RE: Squared Up Short Plat (SP-10-00015)

Kittitas County Community Development Services has determined that the Squared Up Short Plat (SP-10-00015) is a complete application and hereby grants *conditional preliminary approval* subject to the following conditions:

MEMORANDUM

SUBJECT: Squared Up Short Plat SP-10-00015

SQUARED UP SHORT PLAT
 A PTN. OF THE SW 1/4 OF THE SW 1/4 OF SEC. 24, T.20N., R.15E., W.M.
 KITTITAS COUNTY, WASHINGTON

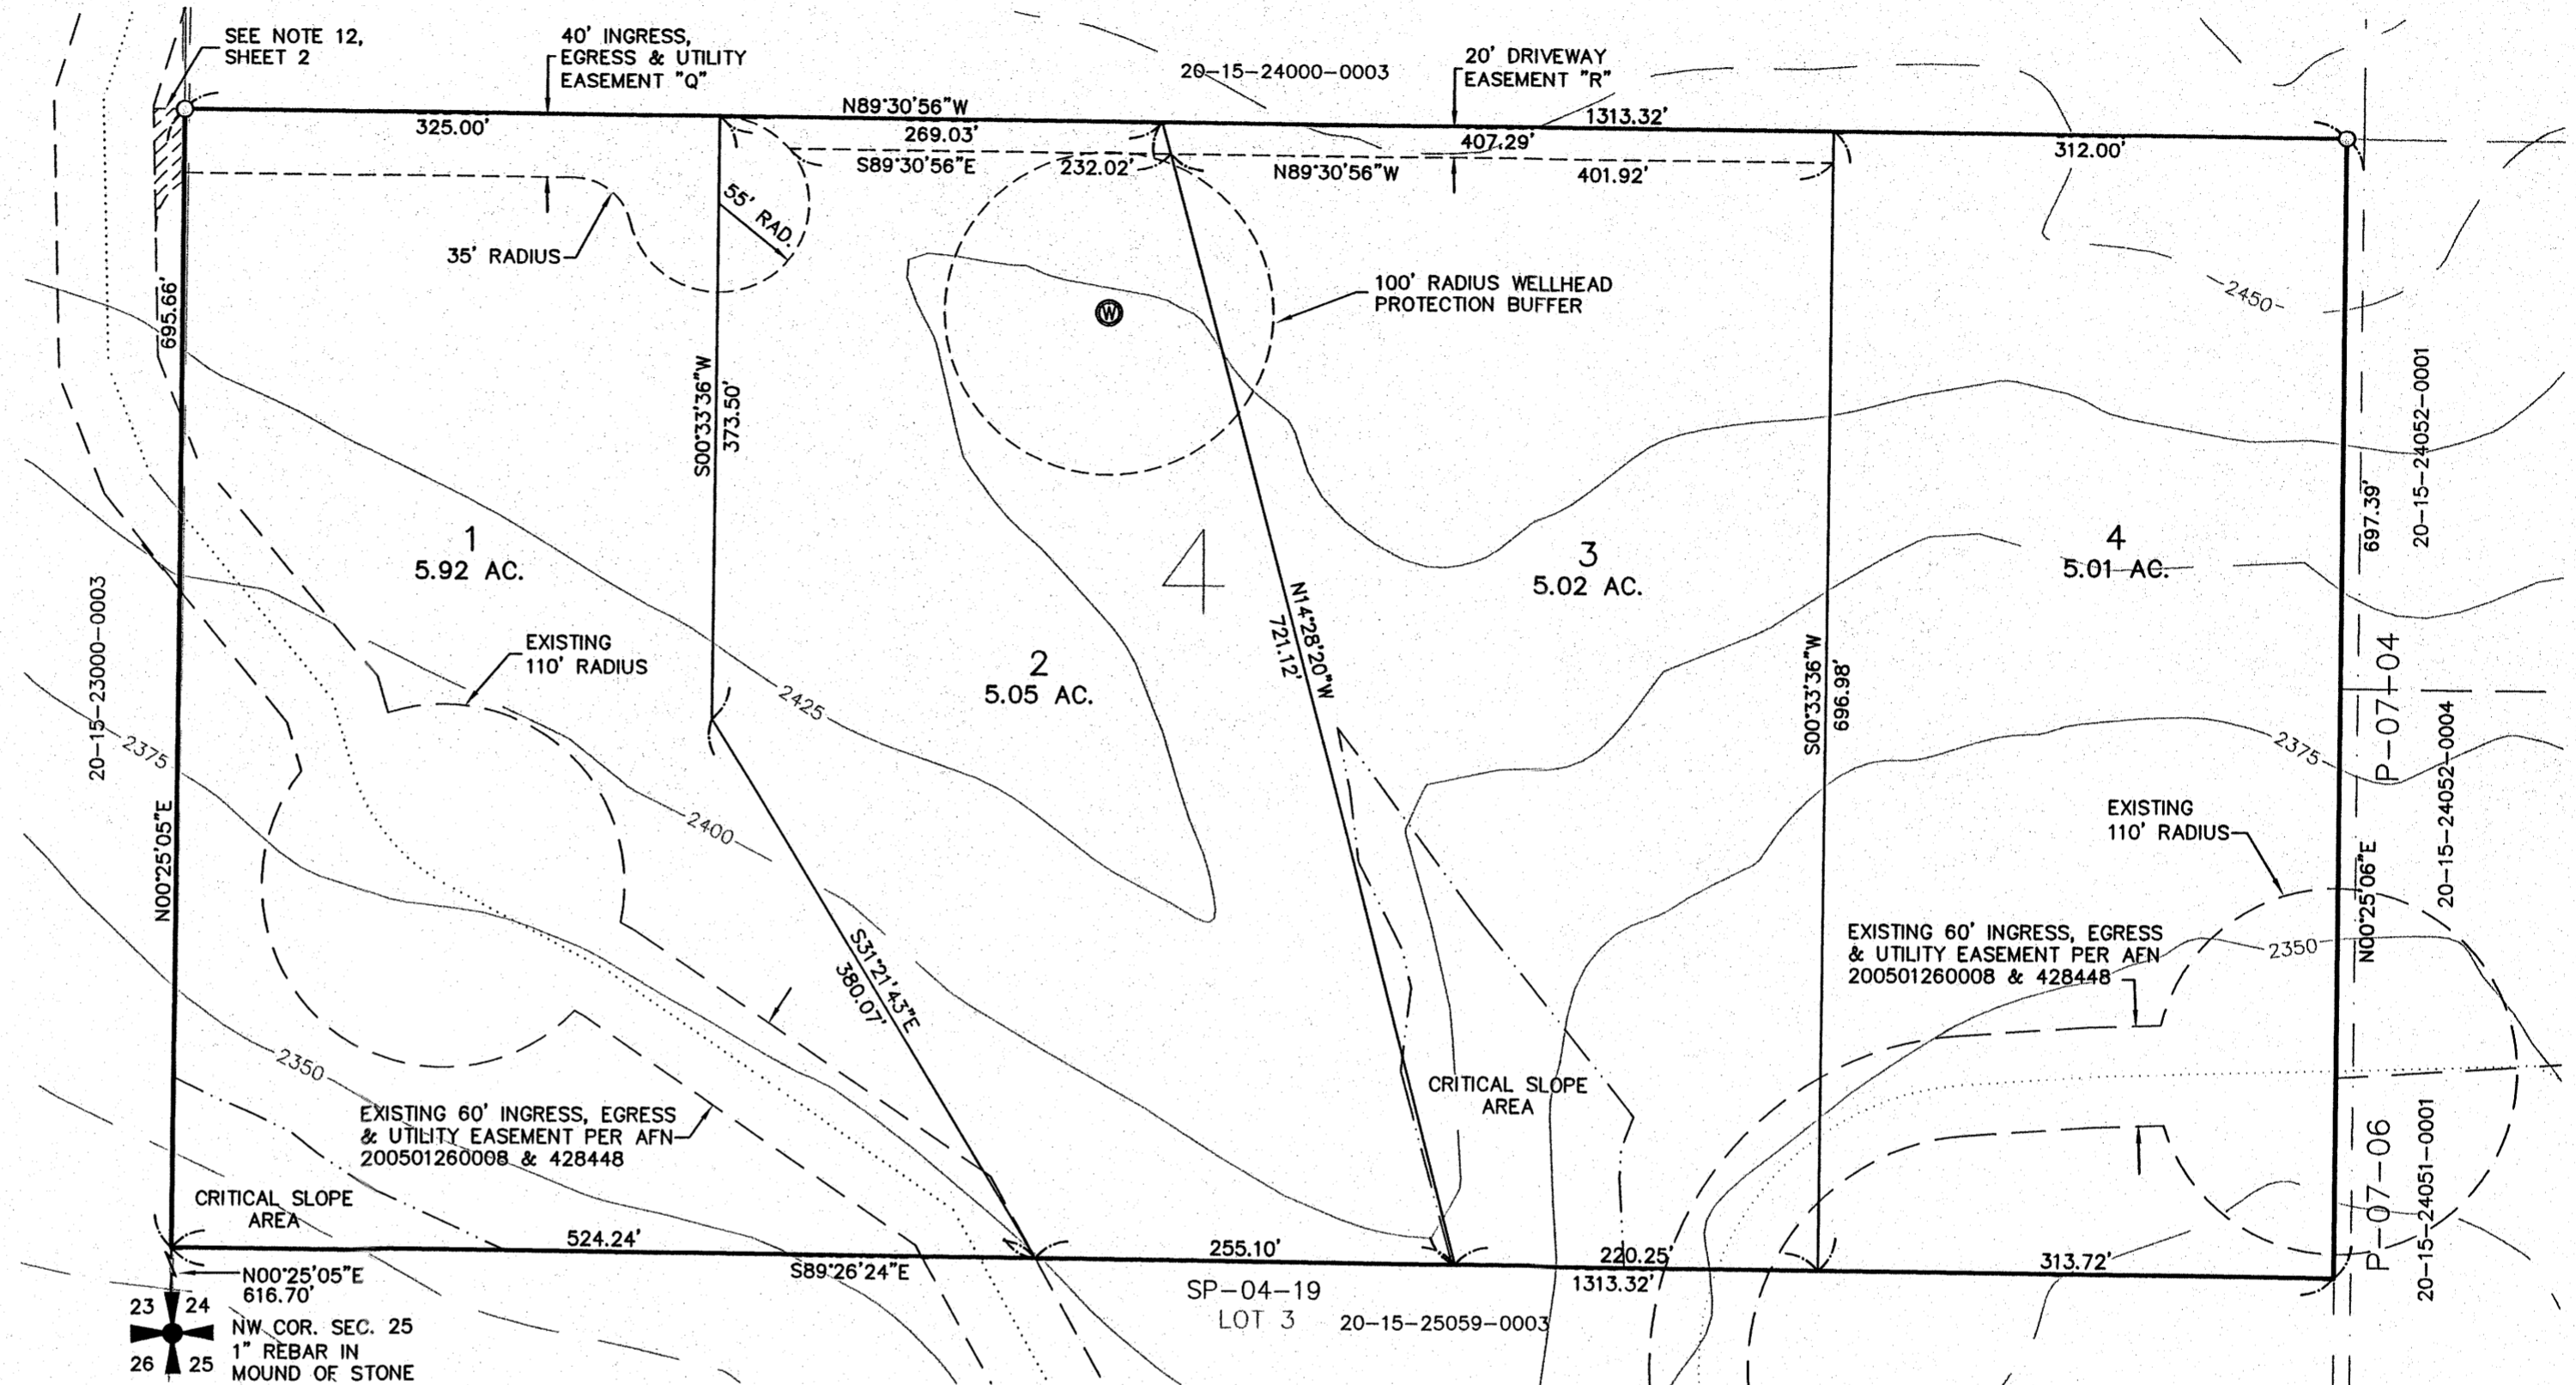
1. Both sheets of the final mylars shall reflect short plat number SP-10-00015 and an accurate legal description shall be shown on the face of the final plat.

3. Second Access: The second access route shall be shown on the final plat, and the roadway improved and certified prior to the issuance of a building permit. The second access shall be built to the same standards of the primary access. The applicant received a variance approving access through the 30' easement section of Deer Creek Road. Refer to RV-08-37.

4. Access: The portion of easement referred to in Note 12 shall be acquired and recorded prior to final approval.
5. Lot 2 Access: Lot 2 shall be accessed directly off the cul-de-sac or road and not use the driveway easement.

6. Road Names: Jack Pine Drive and Forest Ridge Road shall be labeled on the final plat.
7. Private Road Improvements: Access from Cle Elum city limits to the site shall be constructed as a Low-Density Private Road. See Kittitas County Road Standards, 9/6/05 edition.
